***Planning Department
Transportation Development Services***

October 9, 2015

**Re: Baca Townhomes
4421 12th St., NW
Request for Certificate of Occupancy- Transportation Development
Engineer's/Architect's Stamp dated 6-10-14 (G14-D080)
Certification dated 10-8-15**

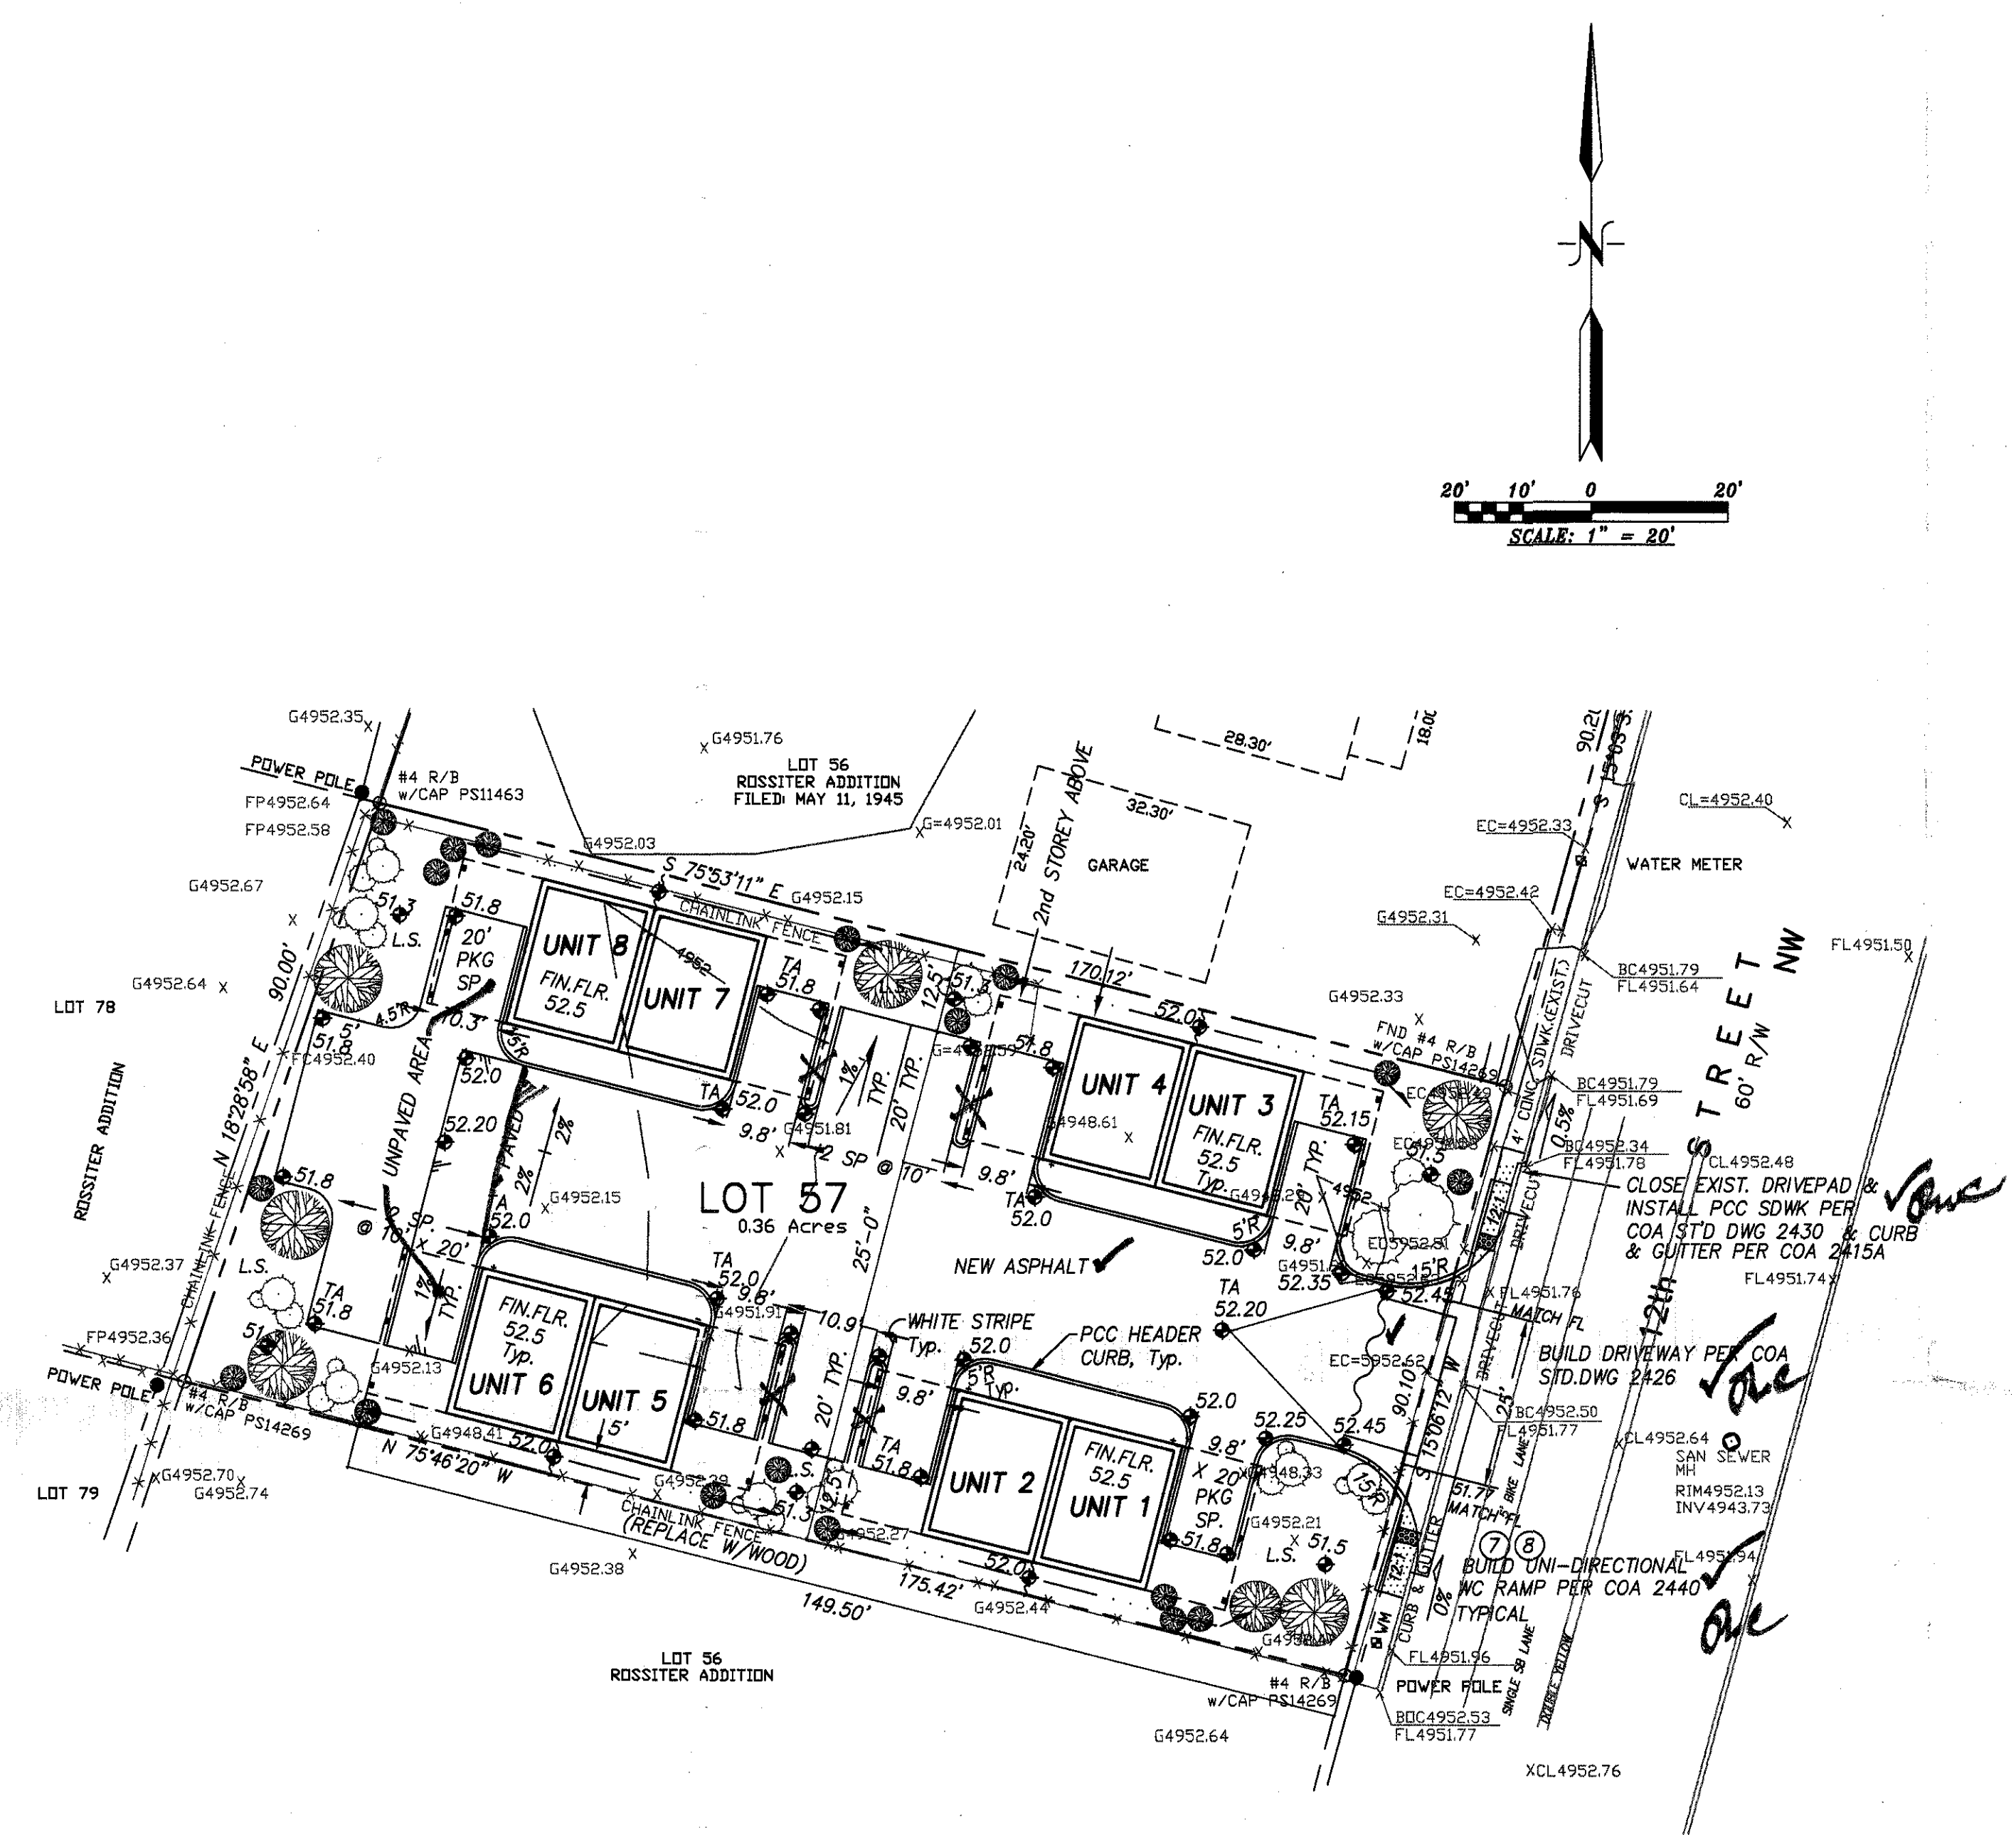
- Per approved plan, parking lot and spaces are to be of asphalt construction. Upon inspection, the parking spaces are not asphalted. Please correct at the project site or change drawings to specify parking surface.
- The approved plans state that 12 parking spaces are to be provided. Upon inspection the parking spaces between Unit #1 and Unit #4 are a total of 14 ft. wide by 20 ft. long, which will not provide adequate parking width for two vehicles. Please submit updated parking lot layout.
- PCC Header Curb on parking lot has not been constructed, as called out on approved plans.
- Truncated Domes at Public R.O.W. handicap sidewalk ramps have not be installed per approved plan.
